Jeanie Bourke - Re: Munjoy Heights - Firewalls

From: Jeanie Bourke
To: Ryan Senatore
Date: 3/5/2014 12:40 PM
Subject: Re: Munjoy Heights - Firewalls

REVISIONS:
 Δ REVISION #1 - 03/05/14

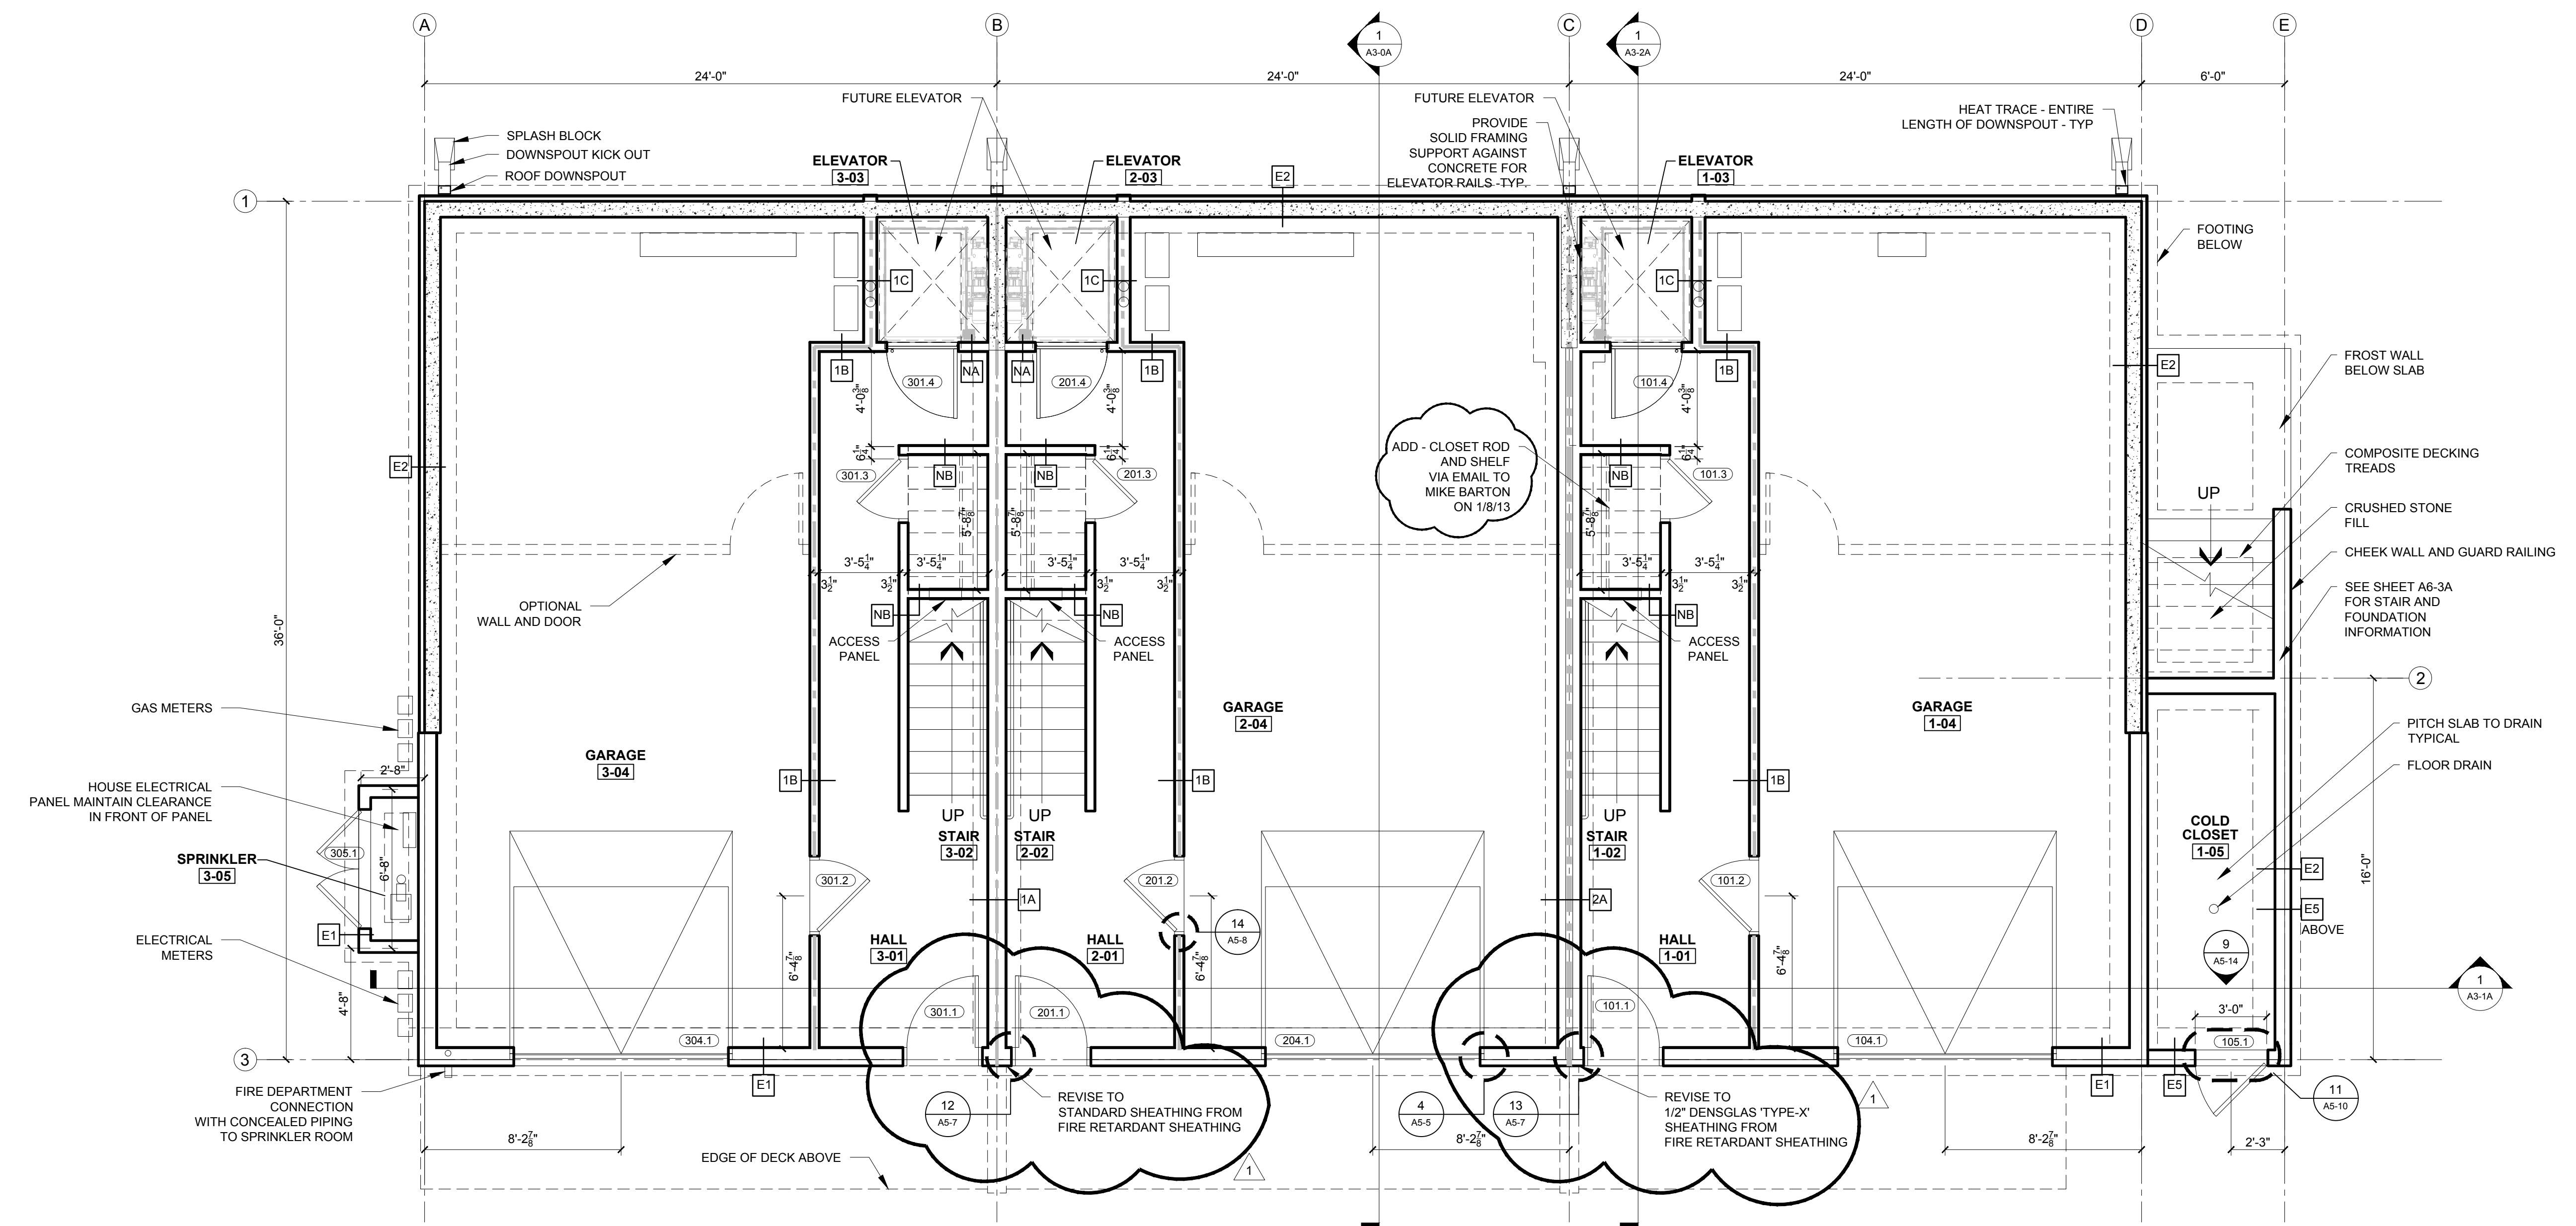
- 1.) We are revising the 2hr wall intersections to 1hr fire rated exterior walls with combustibile sheathing for 48 out from the fire wall per 706.5 ex 1
- 2.) We are revising the 1 hr fire partition intersections to combustibile sheathing and non fire rated.
- 3.) At locations where the 2 hr fire walls have doors and windows within 48" we are using non-combustibile sheathing per 706.5 ex 3

Per our conversation yesterday you agreed to submit these revisions on the plans, which I just received. I just wanted to reply to this email with the correction on #2 from non-combustible to combustibile as I want to include this email with the approved documents.
